Subject: Eagle Rising SP205 Preliminary Plan Reinstatement

Submittal Name:		EDARP Review Comments													
Project Name:		SP205 - Eagle Rising Preliminary Plan Reconsideration													
		Wednesday, January 17, 2024													
Previous Comment Number ID	New Comment Number ID	Document Submitted	Agency	Attachments	Reviewer Name	Reviewer Date	Redline Document	Page	Reviewer Comment	Applicants Disposition	Applicant Response Date	Document	Page	Applicant Comment/Response	El Paso County's Response to Applicant's Responses
1	1	N/A	PCD Engineering Division	Yes	Jeff Rice	11/20/2023 13:25	SP-20-005 – Eagle Rising Fifth Submittal (2022/2023 fourth review)	1	SP-20-005 – Eagle Rising Fifth Submittal (2022/2023 fourth review)	C - Disapproved	1/17/2024	N/A	N/A	<p><b>No written EPC response to applicant's 11/3/2023 response to 9/29/23 EPC</b></p> <p>July 29, 2022 submittal not listed in EDARP</p> <p>Aug 30, 2022 responses not listed in EDARP as new files opened</p> <p>Curiously Comments, Red Herring comments received 3/1/2023 9:20:32 PM</p> <p>Preliminary Plan previously accepted</p> <p>Responses to EL Paso County comments are not considered a new submittal</p>

CREEK ACCESS

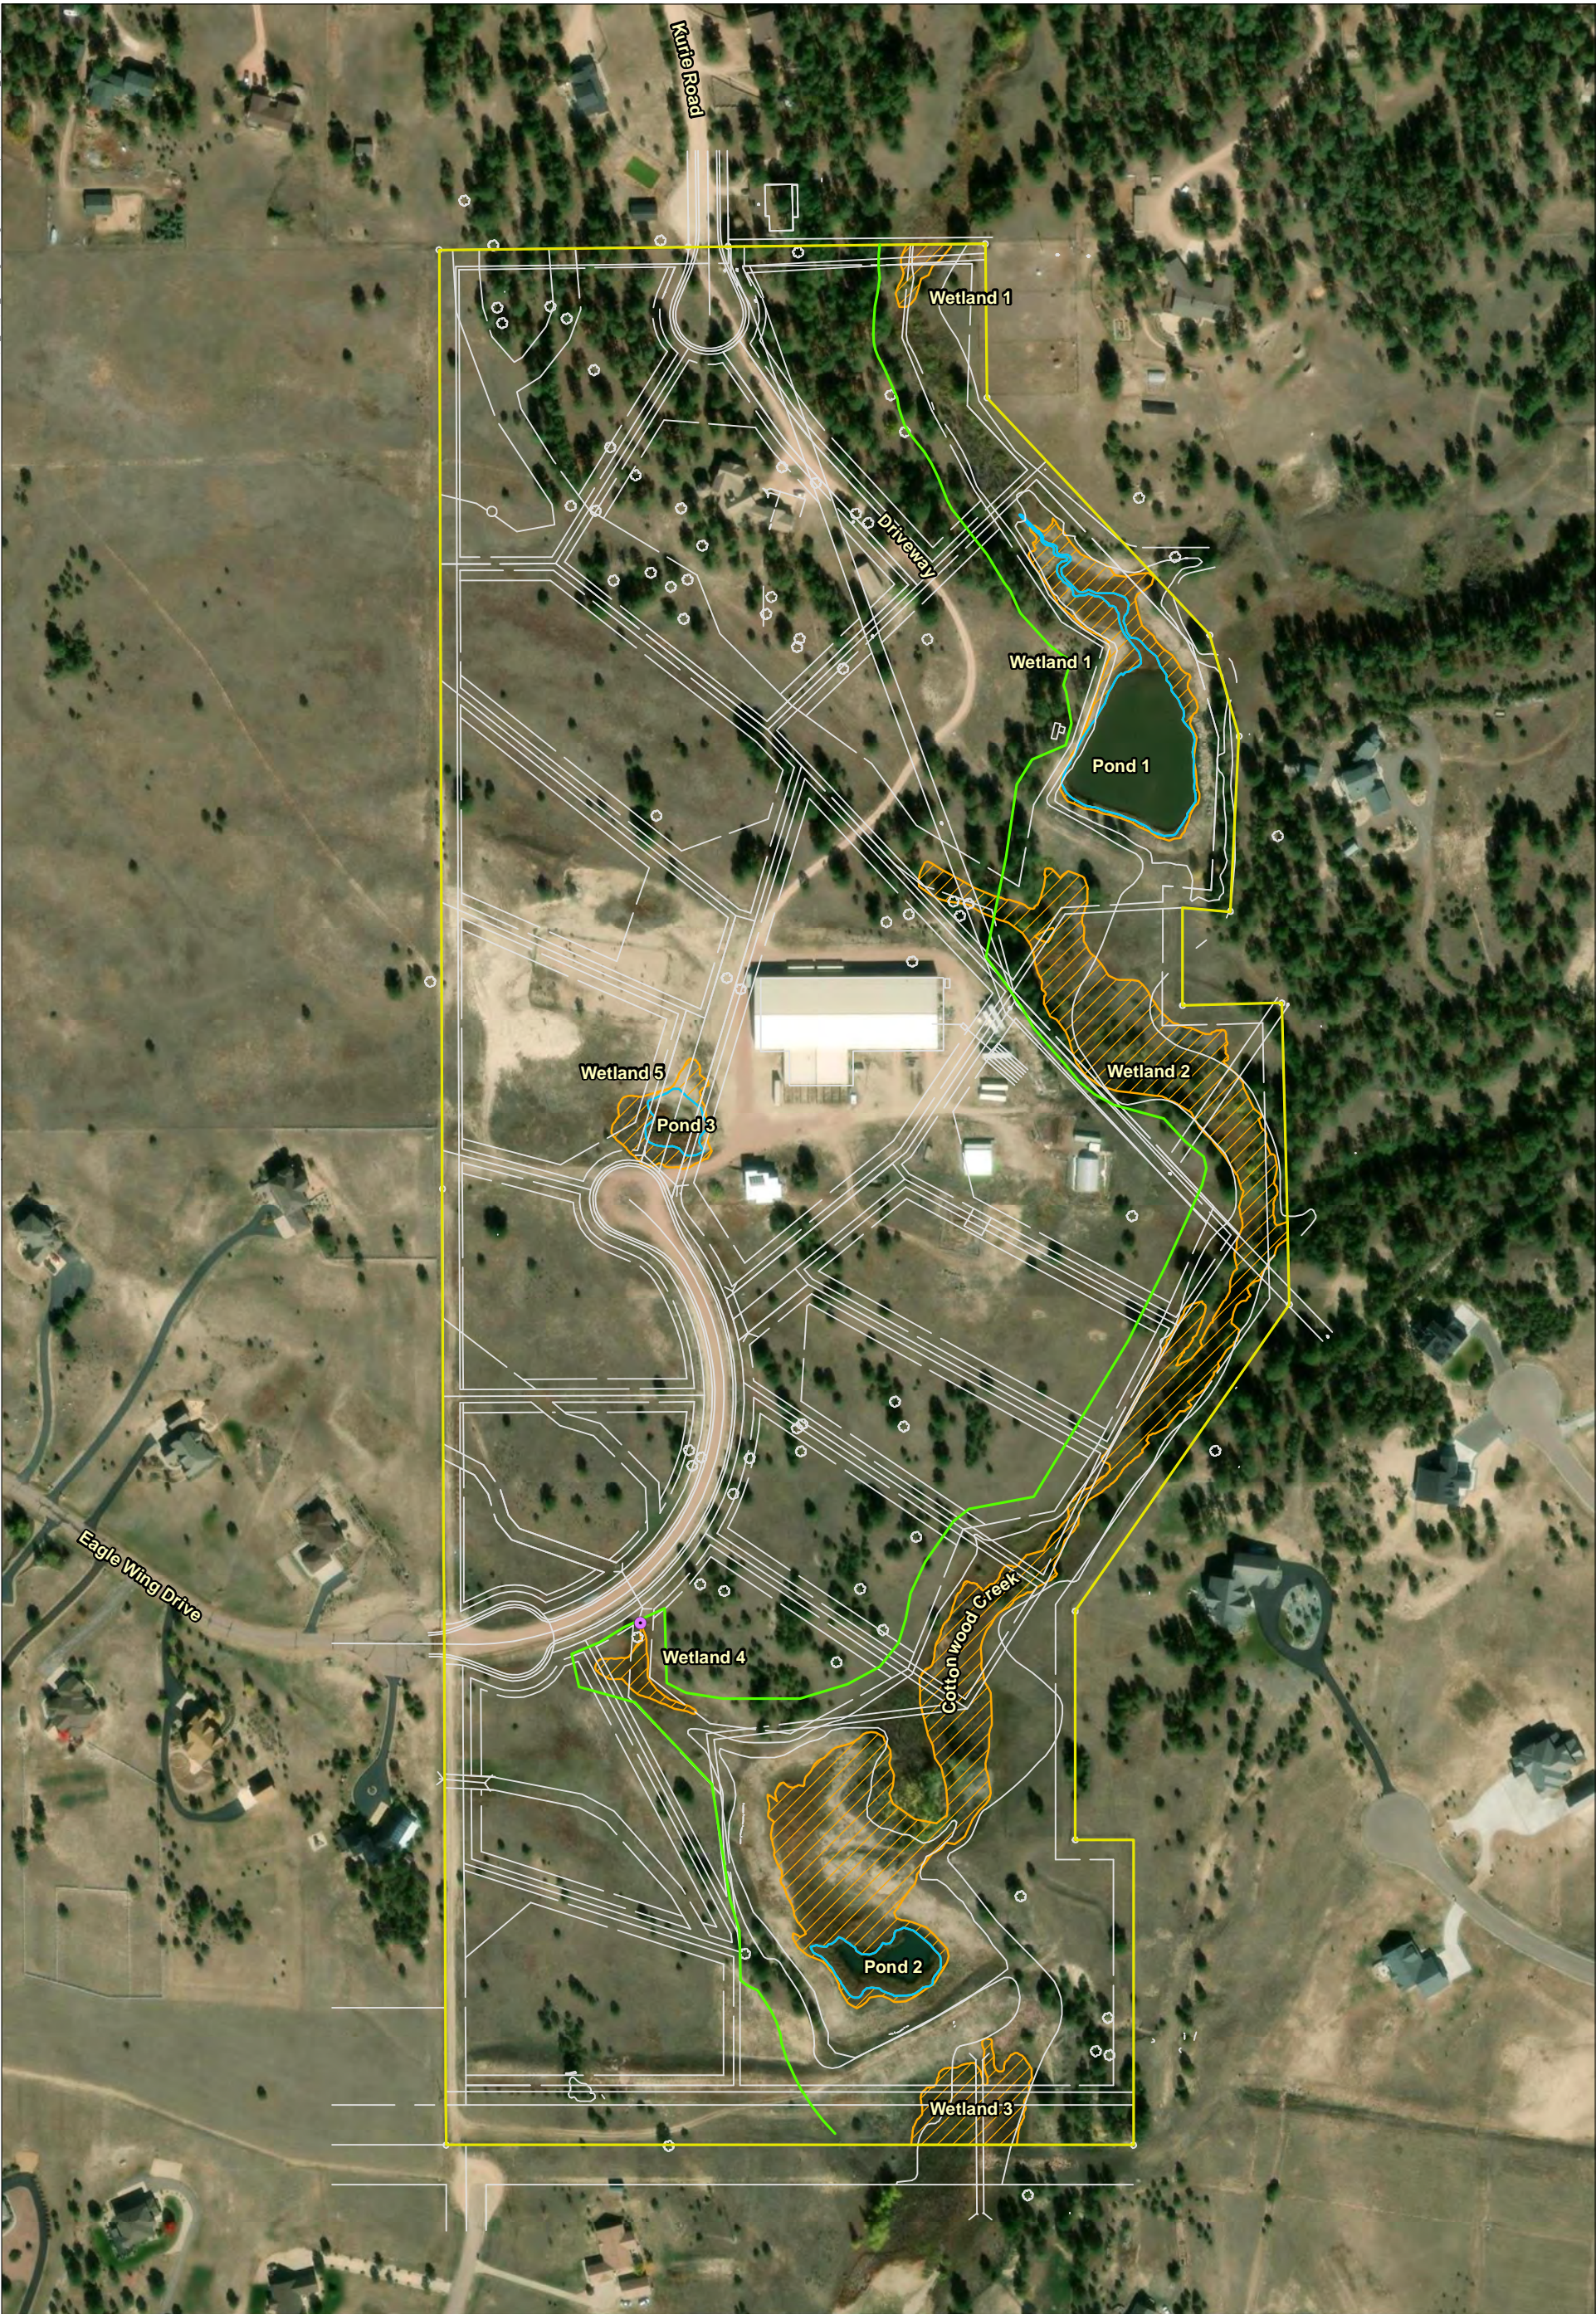
<p>A drawing showing and labeled Creek Access that is in the Final Drainage Report was presented. Appropriate drainage easements will also be labeled Access Easements to the creek. This eliminates construction of 15 foot access roadways. This meets the intent of ECM 3.3.3.k.2.</p> <p>Gorman provided Jeff Rice information and calculations to support that the existing well established willow vegetation yields Froude numbers typically less than 0.3 with only a few that ranging from 0.3 to 0.62 and therefore not supercritical flow except at the dam overflow spillways for the two on-channel ponds. These spillways are protected with rip-rap. Rice to review the new calculations and information provide in the next few days to verify and approve. Rice to connect with Gorman/Timura if needed.</p> <p>A map in the appendix of both drainage reports and the deviation request will be added to the to show photo locations on the map.</p> <p>Revised drainage reports will be uploaded to EDARP for Rice and EPC Team to review.</p>	Gorman	R	O
